PLOT PLAN

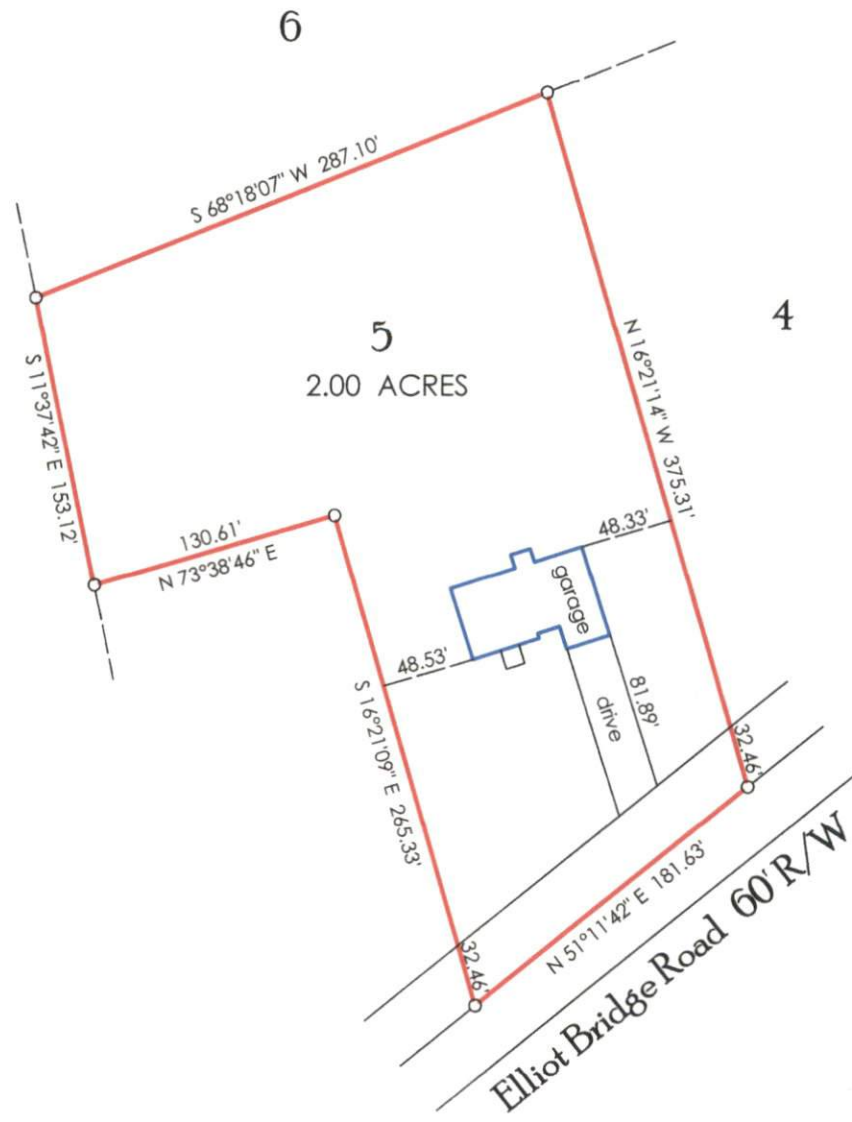
8-31-21  
 - Need Irons  
 - Need cleared  
 - Need House box visible

10-1-21  
 - Need Iron  
 NOT Fence post

9-17-21  
Irons

Show profile locations and other site features (dimensions, references or benchmark, and North)
